Charlotte Storm Water  
600 East Fourth Street  
Charlotte, N C 28202-2844

## Rezoning Petition Review

**Date of Review:** May 20, 2020

**Rezoning Petition #:** 20-67

RZ-3

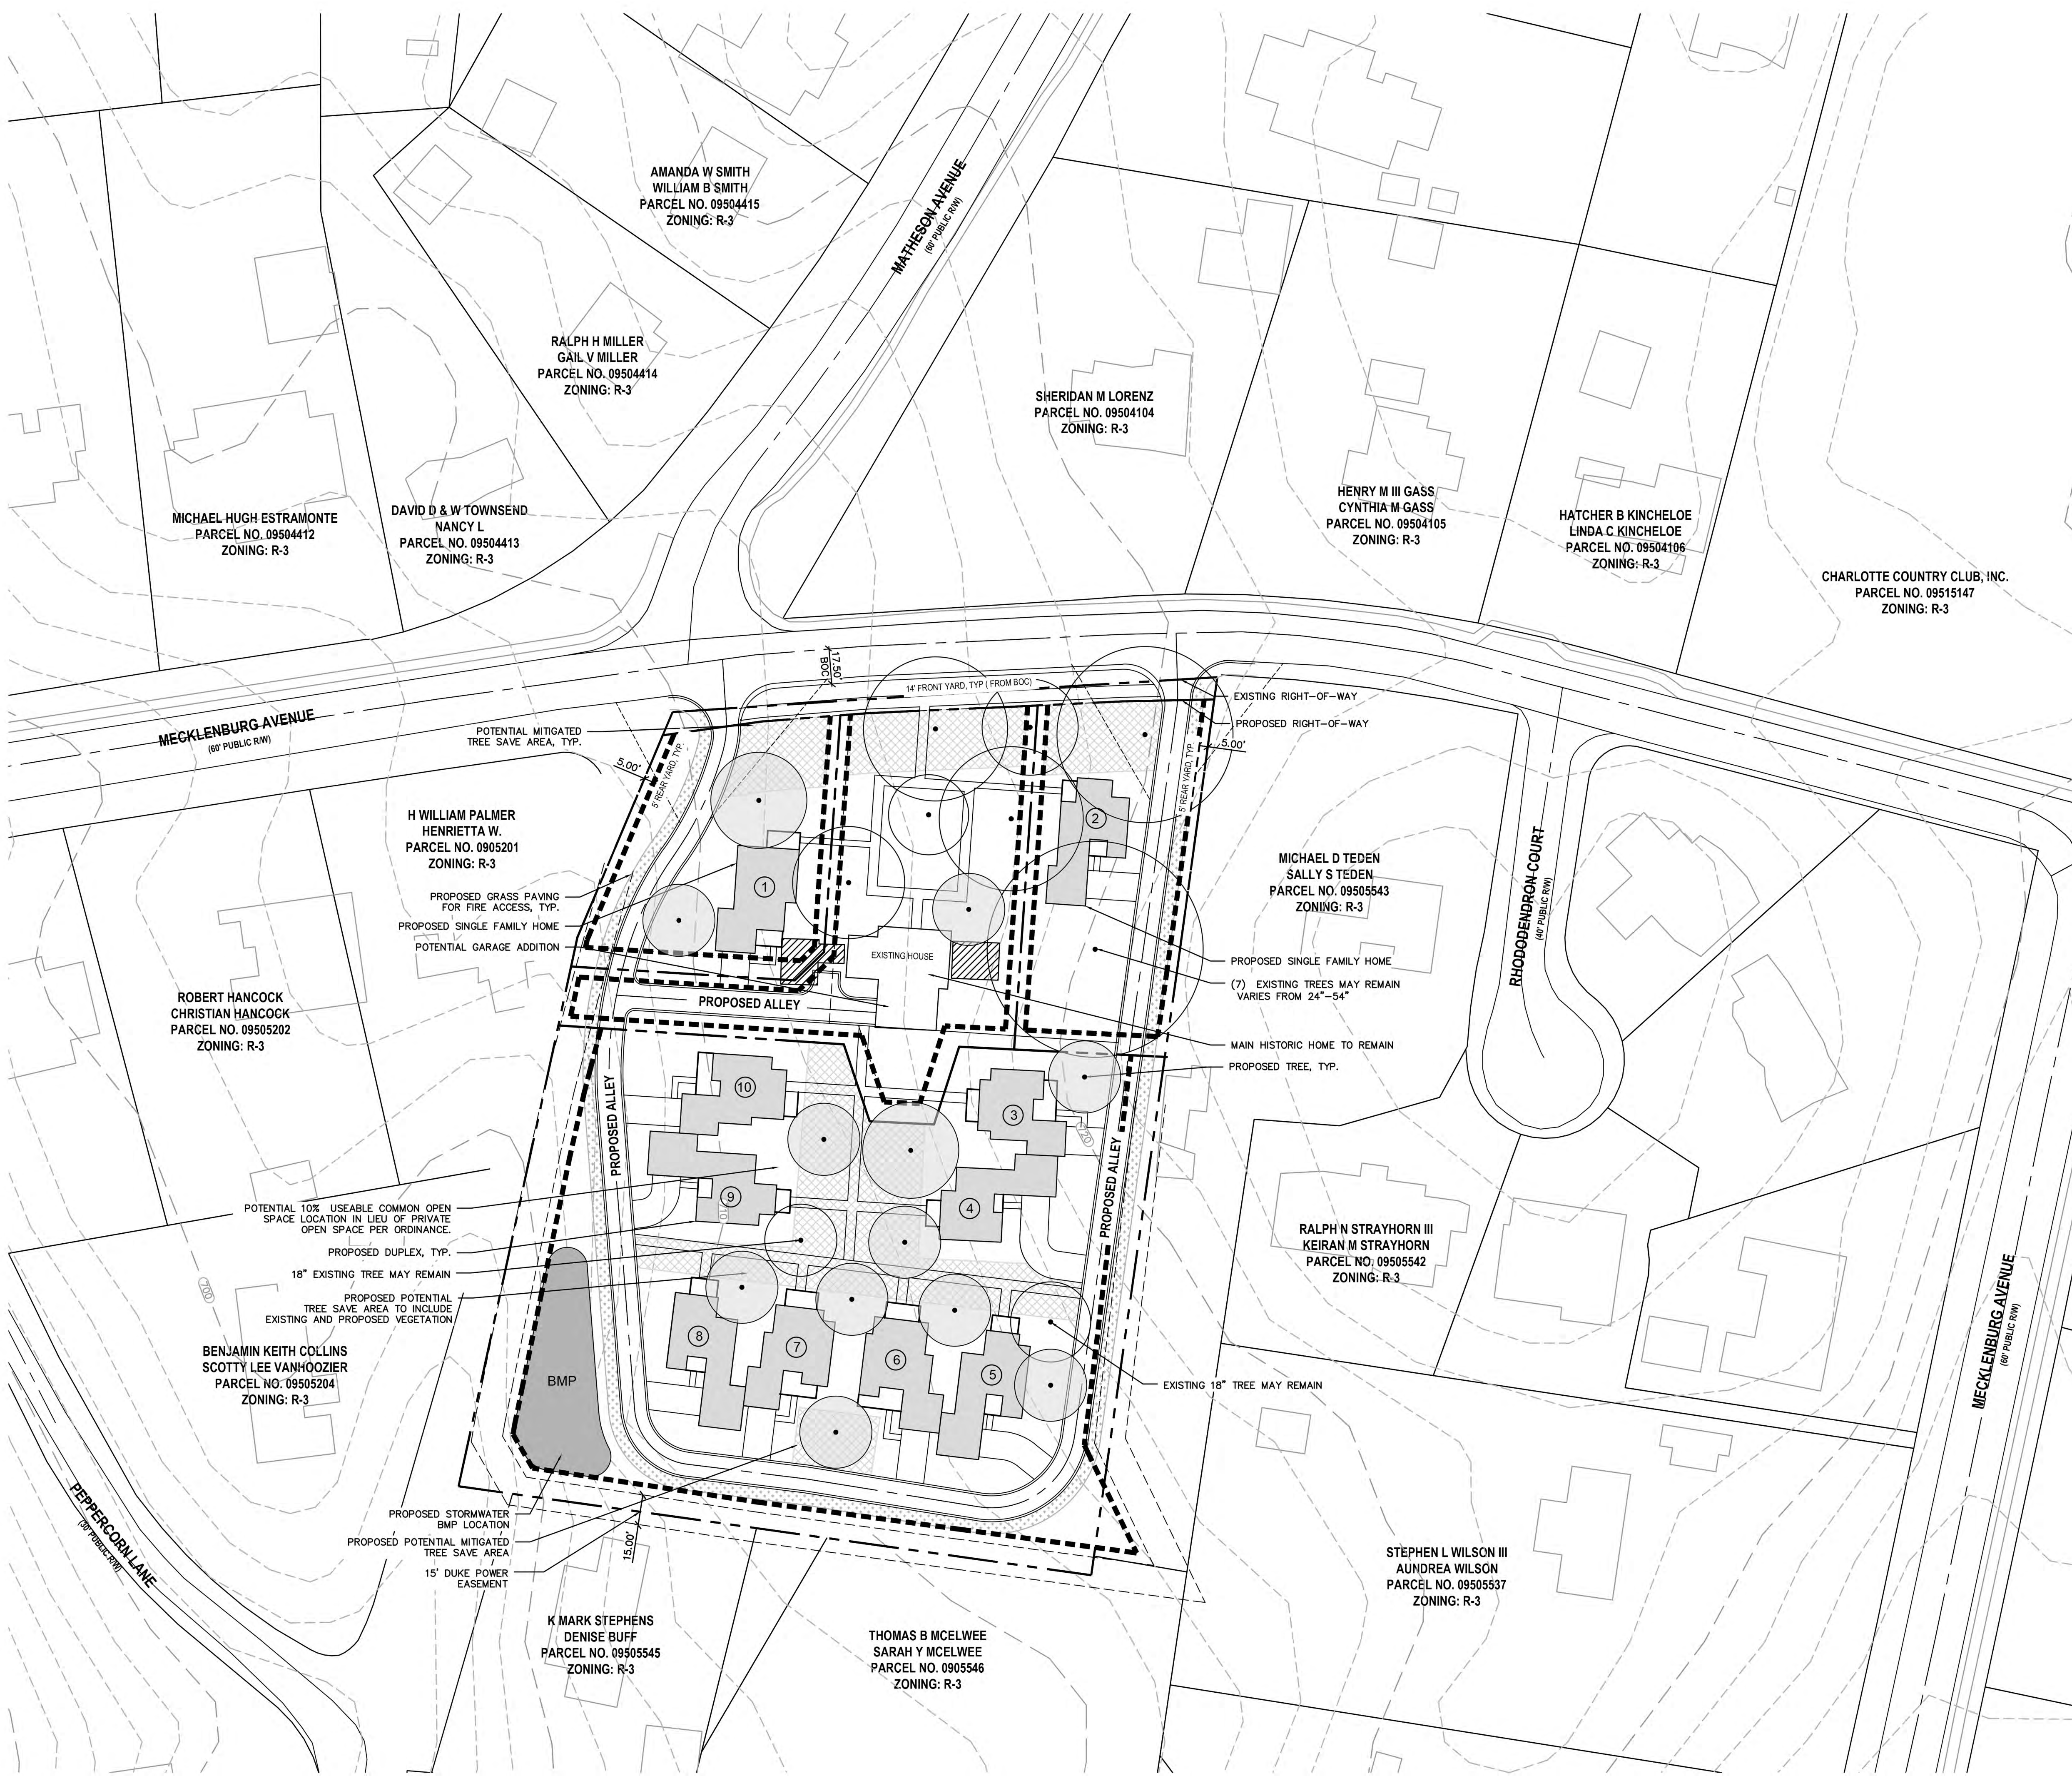
Please include the following note under Environmental Features. *For adjoining parcels receiving storm water discharge the petitioner shall analyze the adequacy of the existing storm water conveyance on the adjoining parcels to the downstream channel (identified by the SWIM/PCSO buffer west of Peppercorn Ln). If the existing storm water conveyance on the adjoining parcels is found to be inadequate, the Petitioner shall make a good faith effort with the property owner(s) to improve the storm water conveyance or mitigate the storm water discharge onto the adjoining parcels.*

**This property drains to Briar Creek, which is an impaired/degraded stream, and may contribute to downstream flooding. This project has the opportunity to mitigate future impacts to this stream, therefore, Storm Water recommends placing the following notes on the plan:**

For defined watersheds greater than 24% built-upon area (BUA), construct water quality stormwater control measures (SCMs) designed for the runoff generated from the first 1-inch of rainfall for all new and redeveloped BUA associated with the project. SCMs must be designed and constructed in accordance with the Charlotte-Mecklenburg BMP Design Manual.

For defined watersheds greater than 24% built-upon area, control the entire volume for the 1-year, 24-hour storm for all new and redeveloped BUA associated with the project. Runoff volume drawdown time shall be in accordance with the Charlotte-Mecklenburg BMP Design Manual.

For residential projects with greater than 24% BUA, control the peak to not exceed the predevelopment runoff rates for the 10-year and 25-year, 6-hour storms or perform a downstream analysis to determine whether peak control is needed, and if so, for what level of storm frequency.
